From: Simon Davis
Sent: 26 April 2022 11:30
To: 'Lisa Jackson' [REDACTED]
Subject: RE: Planning Re-Consultation on: Y/32/22/DOC

From: Laura Gibbons [REDACTED]
Sent: 26 April 2022 10:02
To: Planning.Response [REDACTED]
Cc: Simon Davis [REDACTED]
Subject: RE: Planning Re-Consultation on: Y/32/22/DOC

Engineers Comments Regarding Condition 8

Typical swale/basin gabion outfall detail

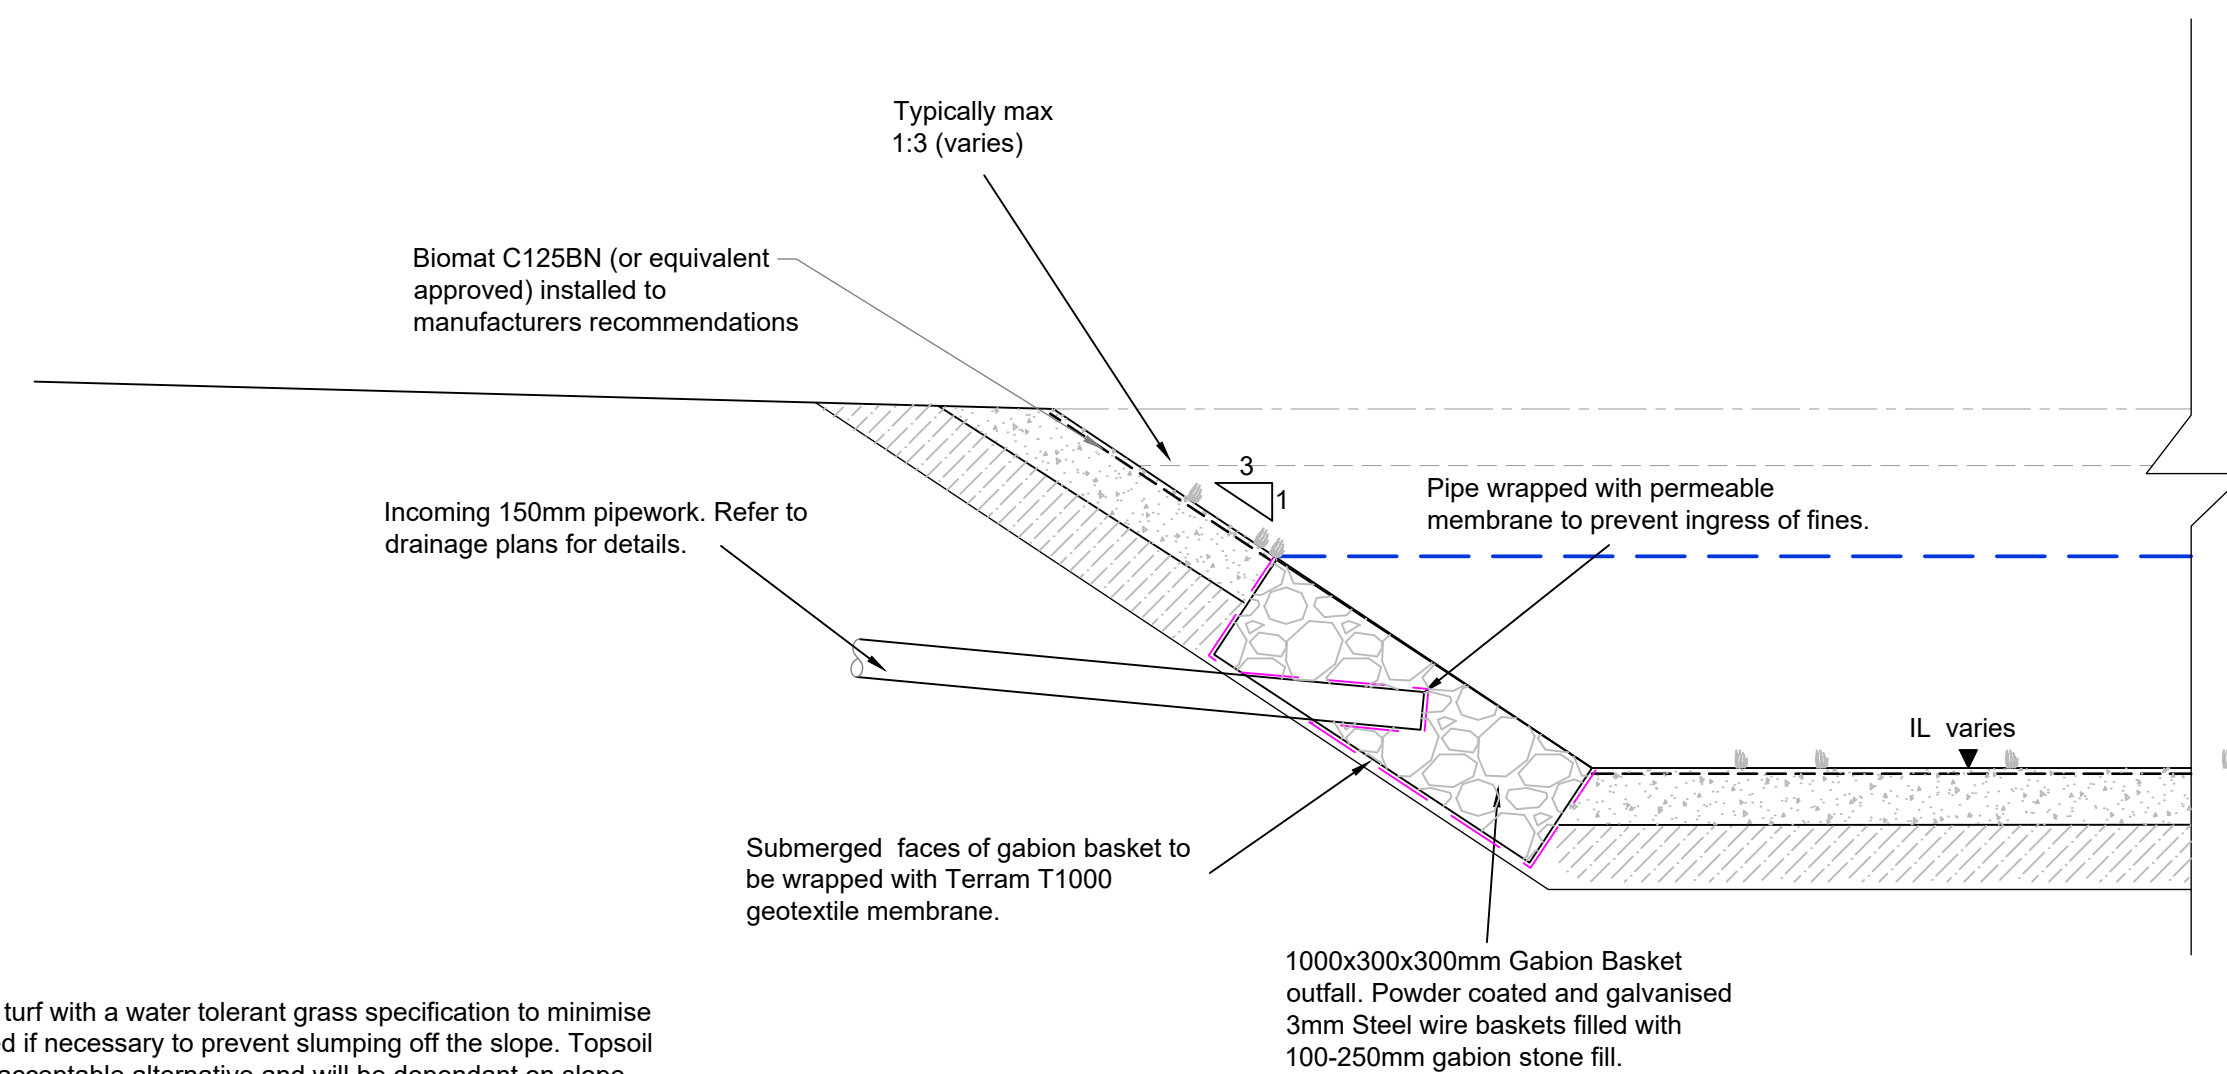
8. The gabion outfall construction detail drawing is unclear. Is it proposed to have buried pipes discharging to the basin? The gabion basket is to be built into the embankment and to be exposed so as to be accessible for

maintenance. The pipework will be within the basket and wrapped in a permeable membrane to prevent build-up of fines. The gabion provides siltation protection as well as dispersal of incoming flow to reduce scour. The gabion basket also removes the need for a traditional headwall and grille, reduces the maintenance requirements and provides a bigger area of contact/surface flow. *Pipework should be exposed and within headwalls. To bury pipework within a gabion will prevent visual inspections for blockage being undertaken. The permeable membrane surrounding the pipe and gabion will likely silt up. Design must be maintainable. The gabion basket headwall is designed to minimise impact to the visual impact vs traditional precast concrete headwall units while allowing free flow of water. The headwalls proposed have been successfully utilised on other schemes and have been encouraged by other drainage authorities; an example can be found on page 76 of the Cambridge SuDS design and Adoption Guide (attached for reference). We do not accept the proposals, as detailed previously "Pipework should be exposed and within headwalls. To bury pipework within a gabion will prevent visual inspections for blockage being undertaken. The permeable membrane surrounding the pipe and gabion will likely silt up. Design must be maintainable"*

Proposed Foul and Surface
Water Drainage Layout
(Sheet 1 of 2)

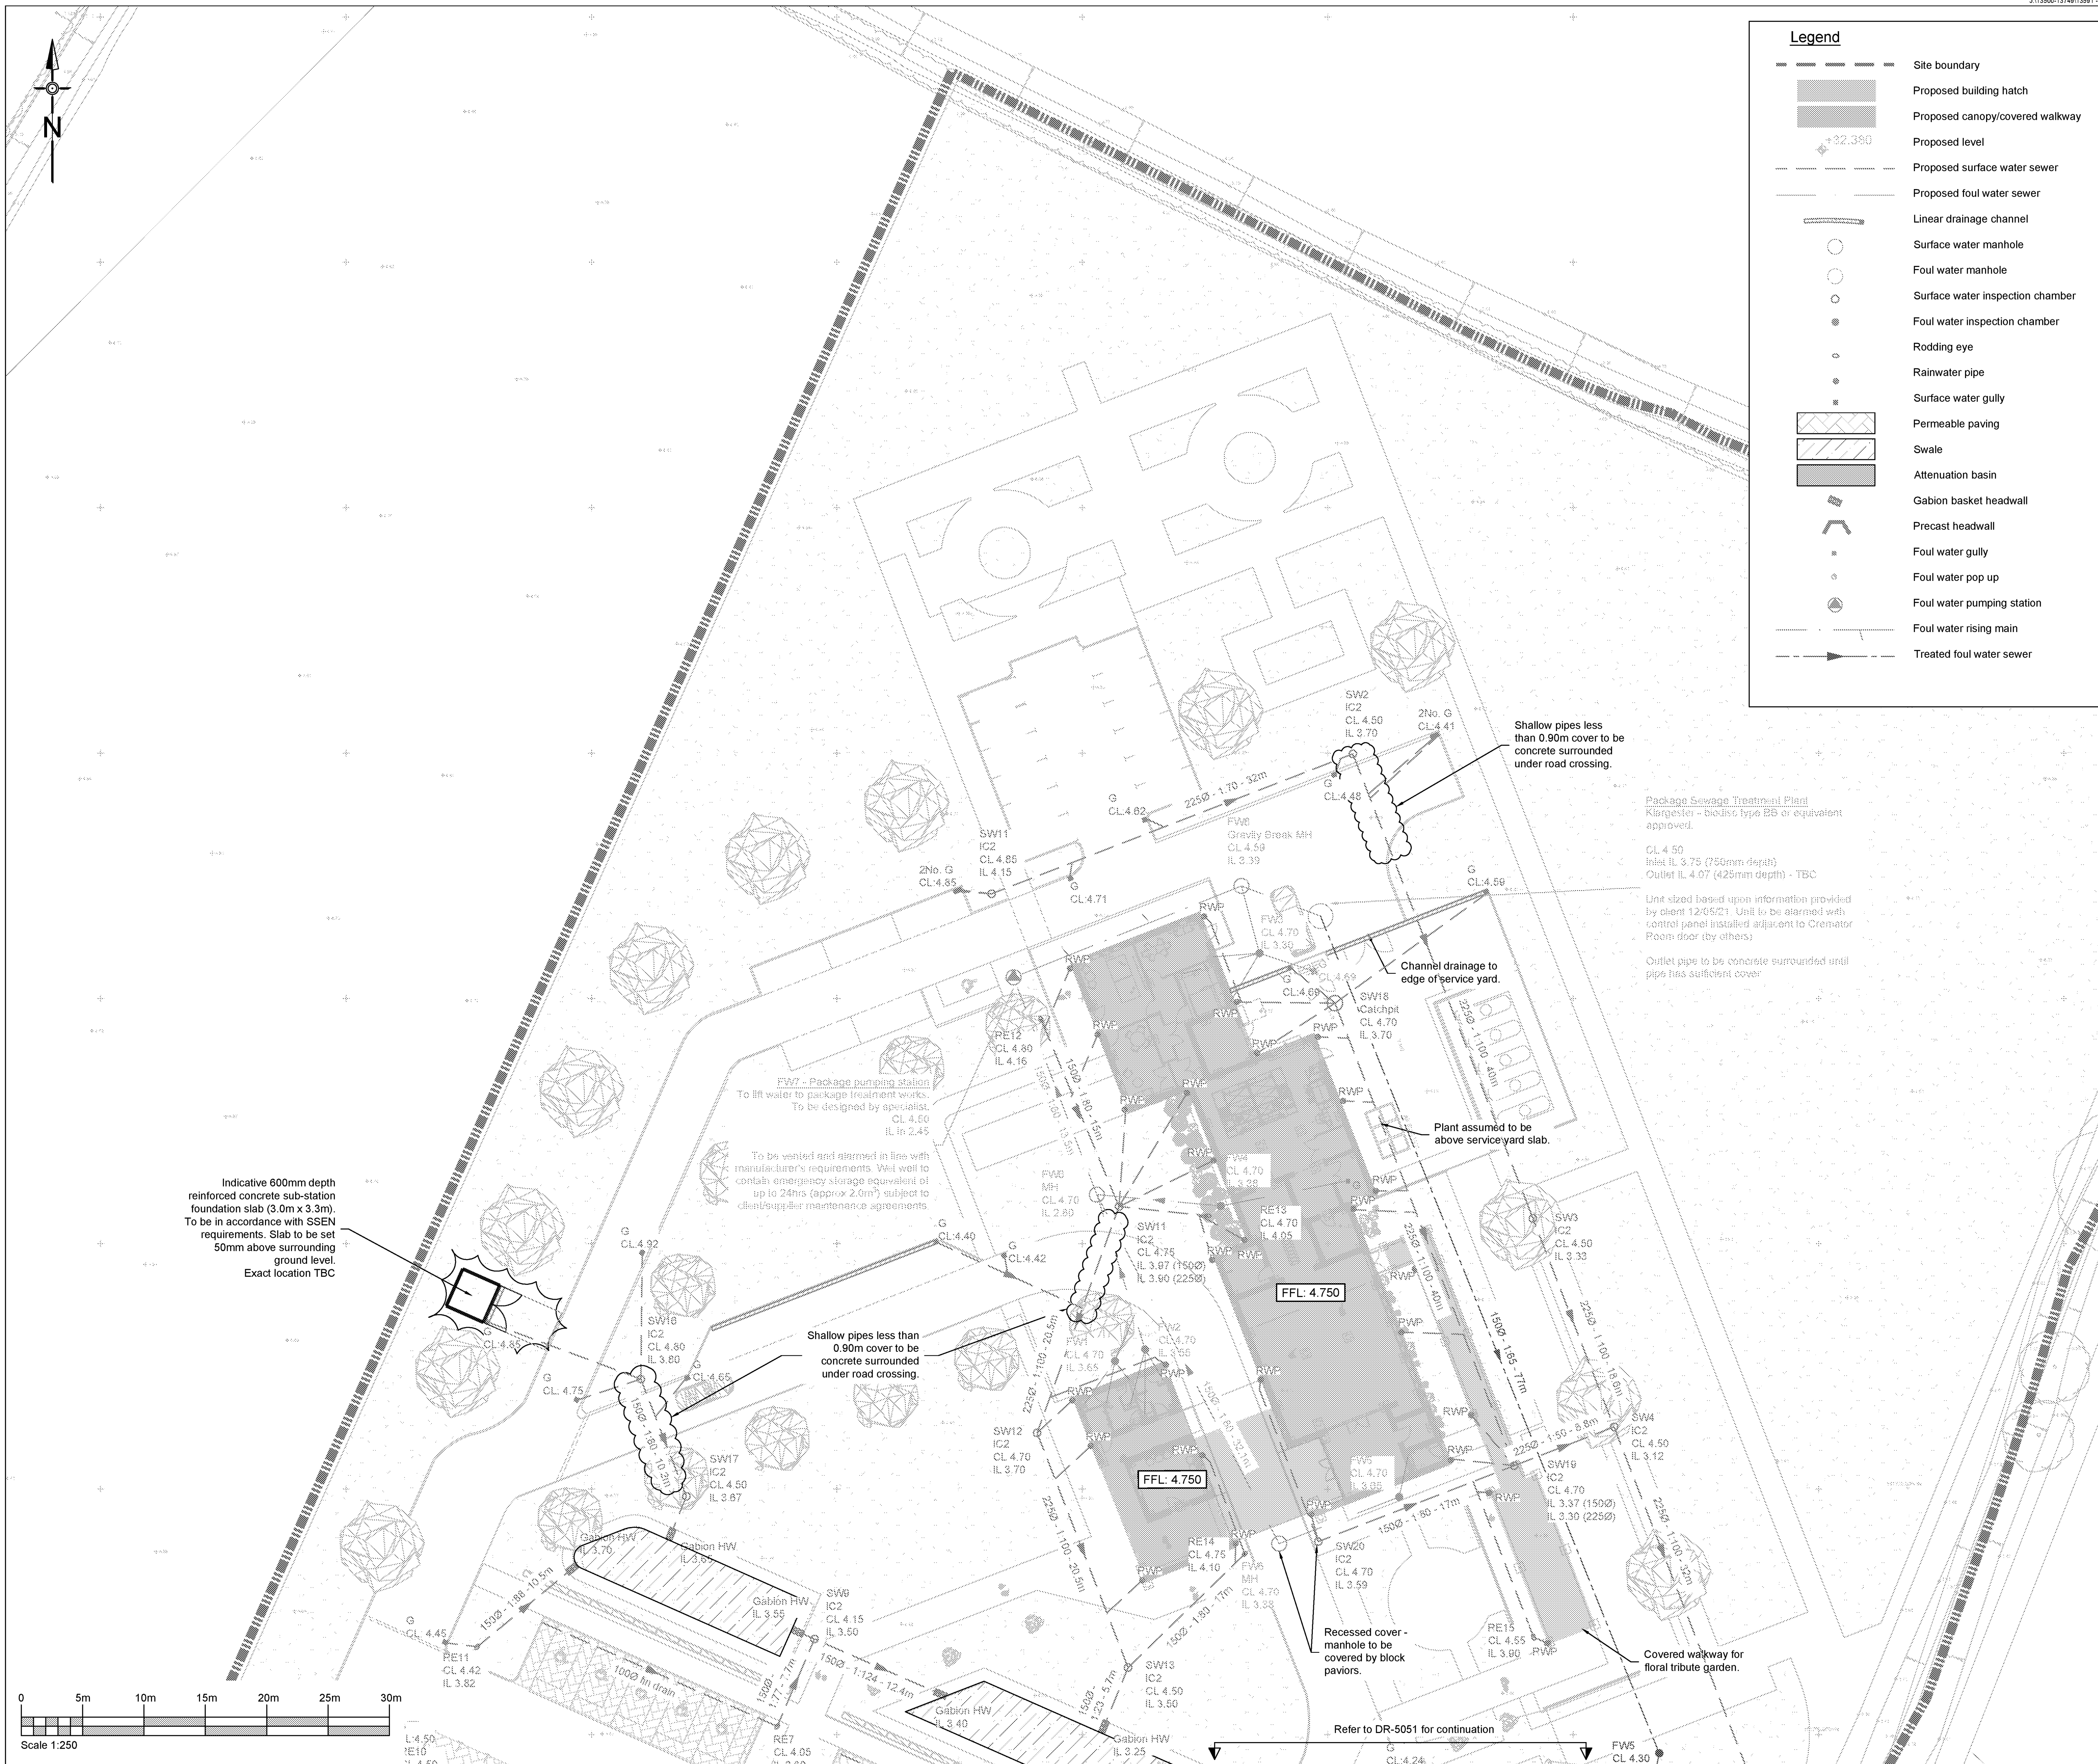
4. Please label all pipes with diameter and fall. Additional pipe labels have been added to drainage layout plans 13591-CRH-XX-XX-DR-C-5050 Revision P6 and 5051 Revision P5. Gradients for short (<5m) pipe lengths have not been shown. Pipe sizes, maximum grades and materials are to be as specified on drainage notes drawing 13591-CRH-XX-XX-DR-C-5300 Revision P1 previously provided. Okay.

7. Gullies and channel drains should be labelled with cover levels. Cover levels have been provided for proposed gullies on updated drainage layout plan 13591-CRH-XX-XX-DR-C-5050 Revision P6 and 5051 Revision P5. Channel drain cover levels will necessarily vary along the length and hence have not been provided. Exact levels will be determined by contractor to suit the finished levels as shown on levels plan 13591-CRH-XX-XX-DR-C-5200 Revision P3. Levels should be provided on plan to ensure construction is carried out in accordance with proposals. Channel drain cover levels have been added to drawings DR-5050 and 5051 as requested. To be reviewed once an updated set of calculations is provided.

2. Please supply a buffer plan to show that at least 3m is being provided between top of bank of watercourses and obstructing features, such as fences, buildings, and basins. A suitable buffer has been provided between top of basin and edge of watercourse to allow for maintenance, as shown on drawing 13591-CRH-XX-XX-DR-C-5051 Revision P5. *Buffer not clearly shown, please show the buffer on a plan. A buffer has been shown on drawings DR-5050 and 5051 as requested. Okay.*

Proposed Foul and Surface Water Drainage Layout (Sheet 2 of 2)

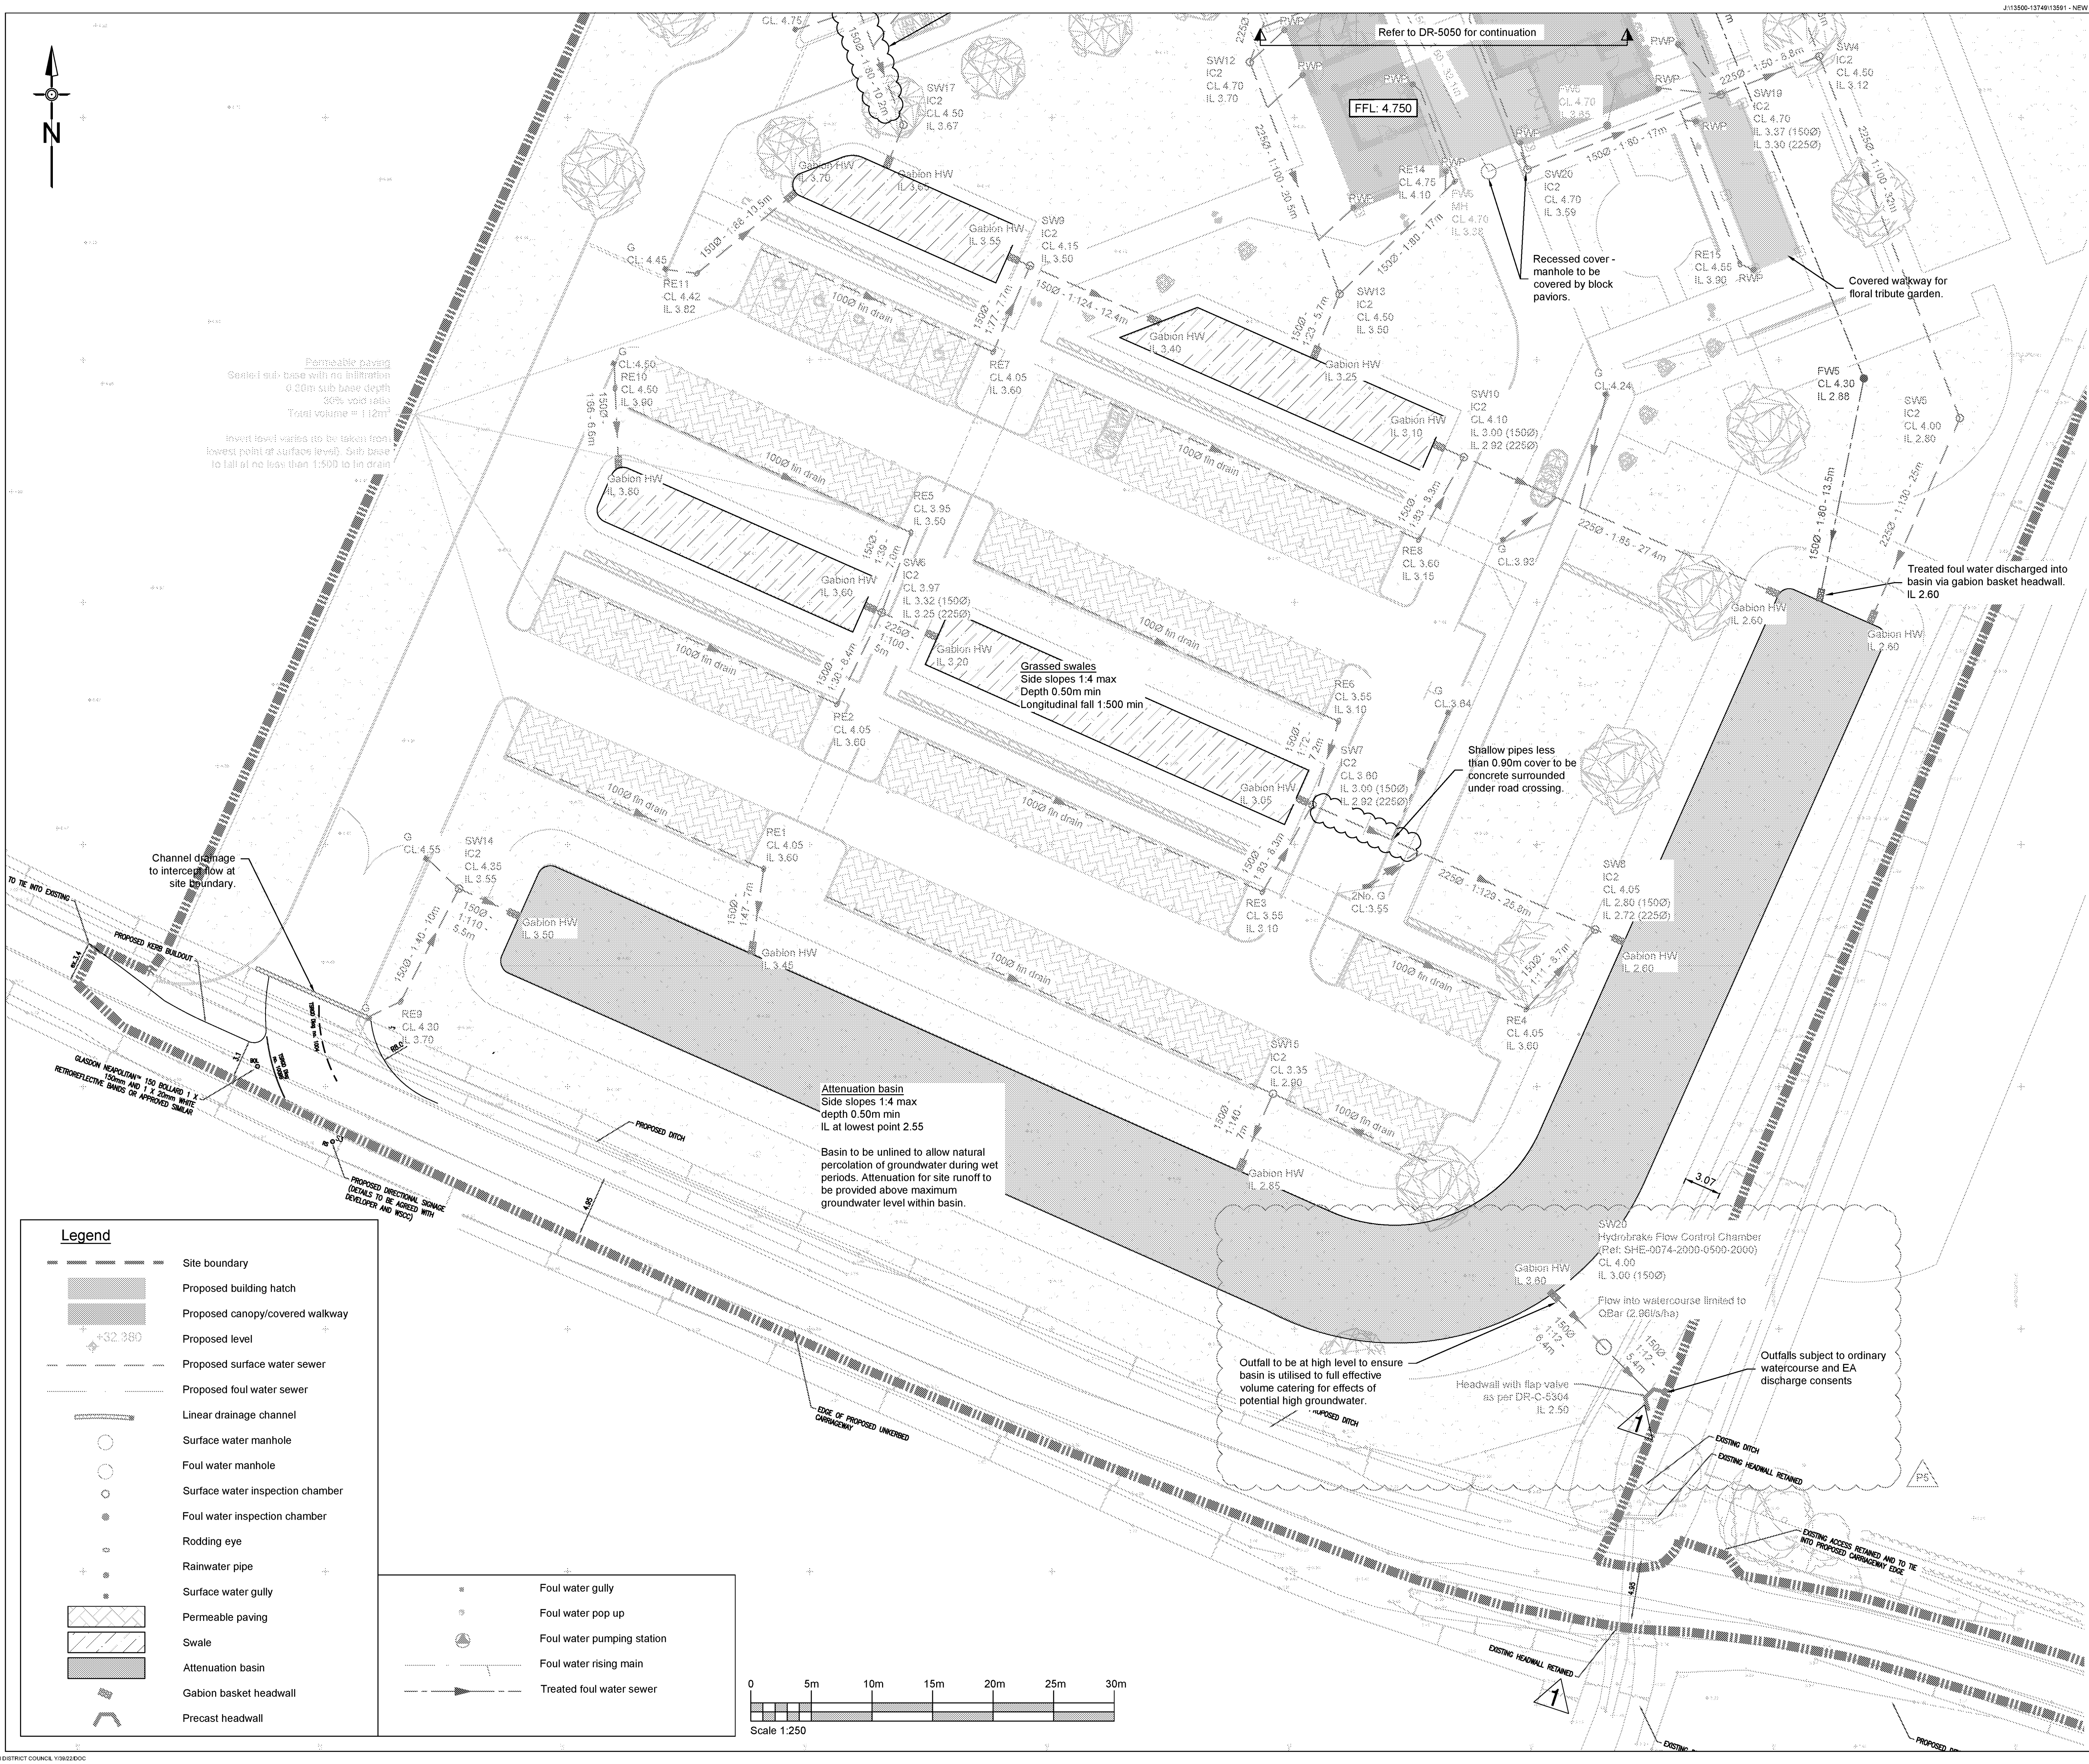
5. Hydrobrake unit references should be included on layout plans. Details have been added to updated drainage layout plan 13591-CRH-XX-XX-DR-C-5051 Revision P5. Okay, but please see comment above for more detailed calculations to evidence a compliant design. Hydrobrake reference on plans matches the calculations.
